Response to Submissions re 85 Harrington Street Development Application						
Date of Issue: Wednesday, 18 October 2017						
Source	Item	Issue/Object	Description	ADG Objective	Drawing Number(s)	FJMT Responses
DoPE Letter Attachment A	1.1	Visual Privacy	Balconies serving units on Northern side of Building 2 have been reorientated towards Rendezvous Hotel. Provide a specific plan illustrating the varying setbacks between the two buildings, location of facing windows and balconies and proposed design measures to mitigate potential privacy impacts.	N/A	002 - 003	Solid, operable shutters, or horizontal metallic blinds that are controlled by the occupants of the unit are employed to provide privacy towards the subject site. The windows of question within the rendezvous hotel are fixed, have dark glass and the rooms are itinerantly occupied. Any potential privacy issues have been mitigated through a considered design response. Complies? Yes

85 Harrington Street
The Rocks
GOLDEN AGE & HANNAS THE ROCKS

TITLE
RESPONSE TO DoPE
Responses to Items

drawing title Swept Path Parking Review Basement Level 1			
drawn:	MM	checked:	MM
date:	01-02-2016		
project no.	14.563	drawing phase.	-
drawing no.	SK.08	rev	-

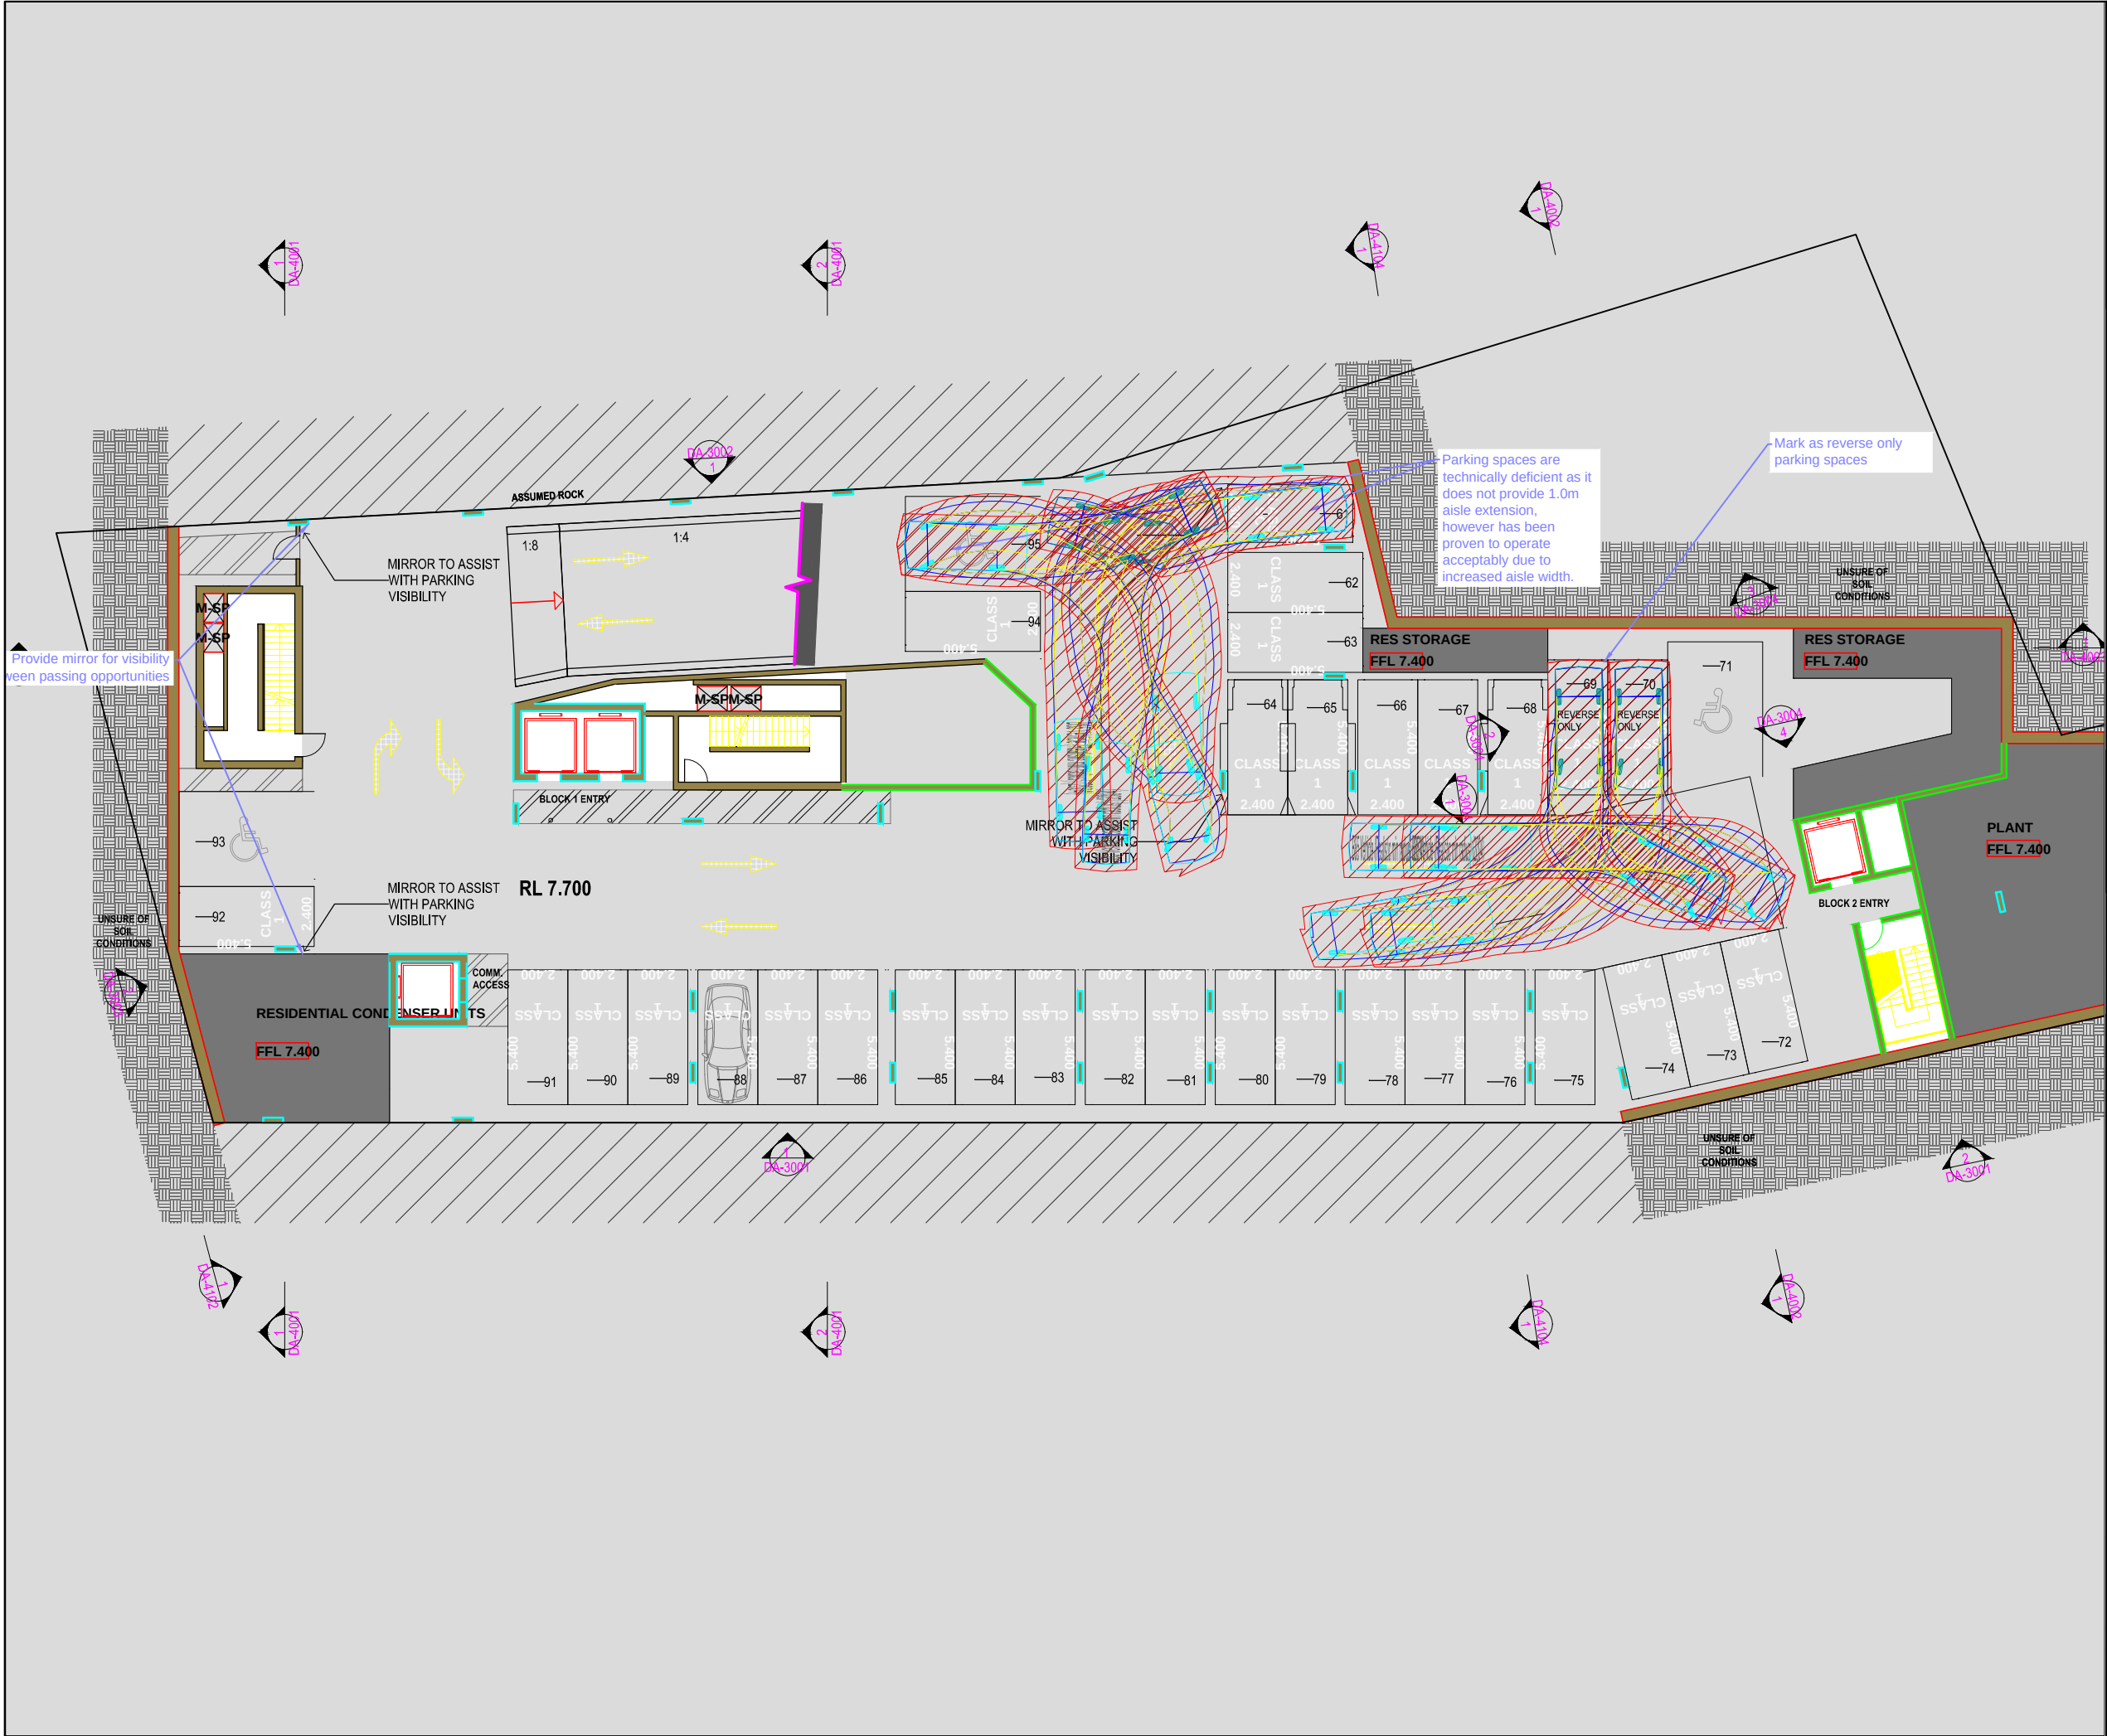
5.5		Note that proposed car park layout does not comply with the relevant Australian Standard AS/NZS 2890.1 with regard to aisle turning, clearances and ramps		043 - 044	Please refer to additional information provided by Traffic Consultant Complies? Yes
